PLANNING AMENDMENT

| SITE ADDRESS DETAILS Norwood House, Station Road, Gedney, PE12 0DD | |

| FULL DESCRIPTION OF DEVELOPMENT OF CURRENT APPLICATION THAT THIS AMENDMENT RELATES TO | Proposed Garage with Storage Above | |
| State drawing numbers of the current submission | 4186-23- 10B | |

## SOUTH ELEVATION

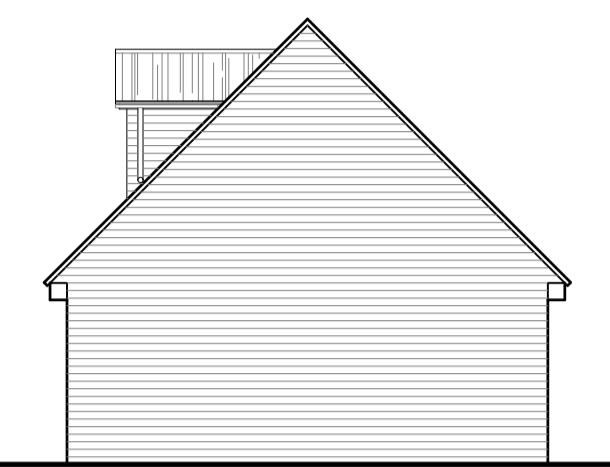
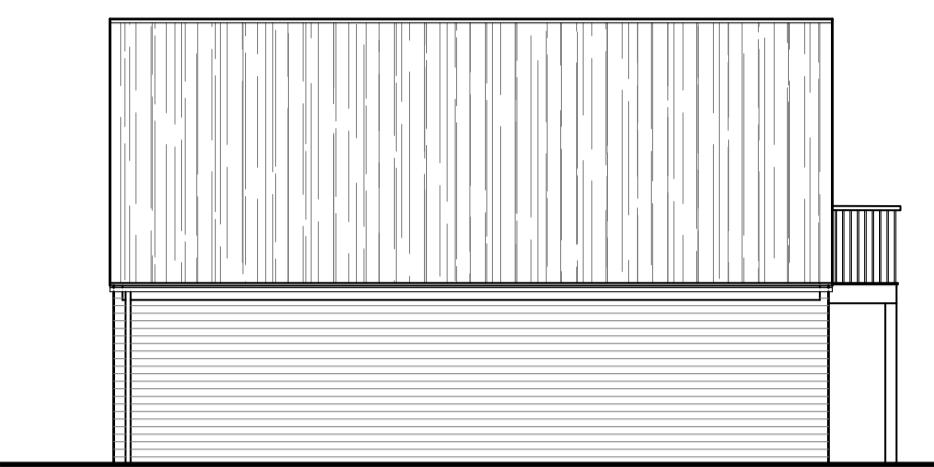
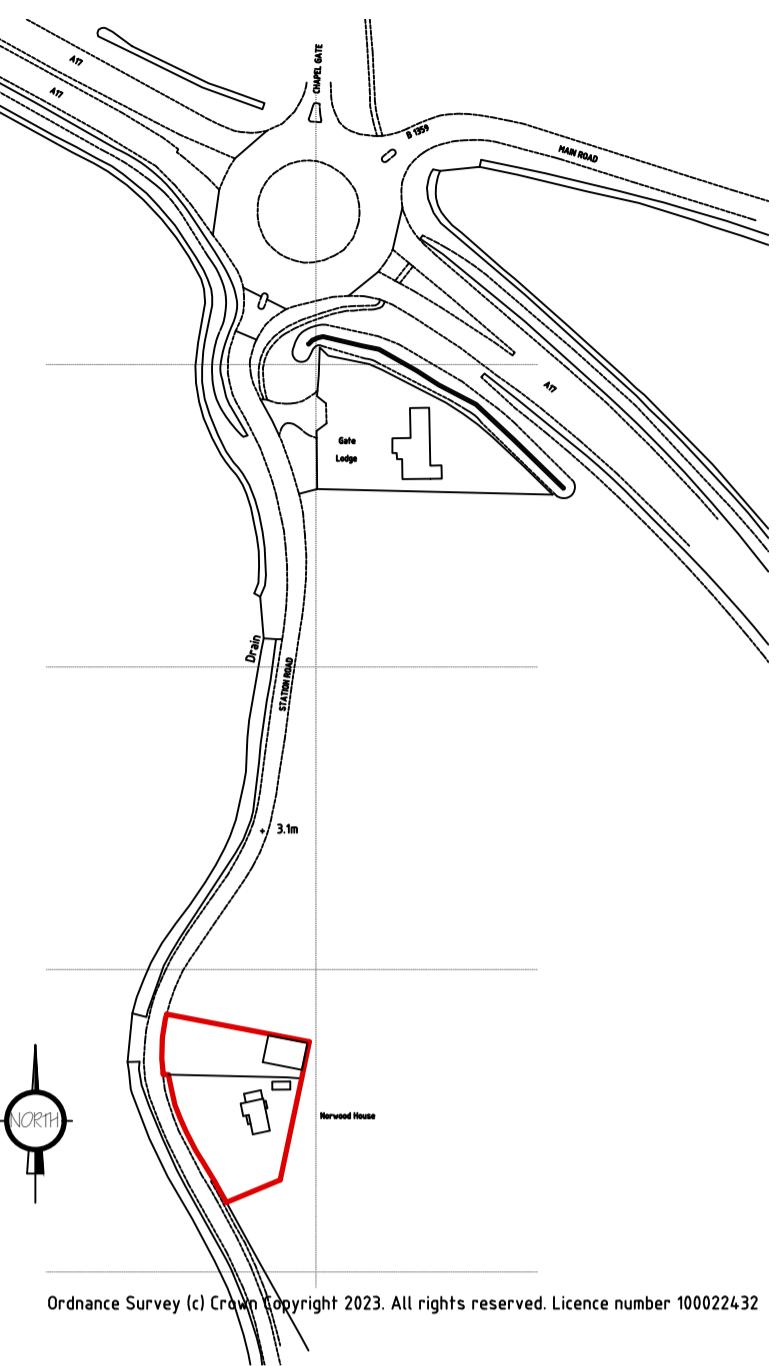
| State details of amendments proposed. (Give a full detailed list of the changes, and also mark these clearly on the accompanying plans. Only the changes listed here will be considered) | Garage height amended and Landscaping added | |
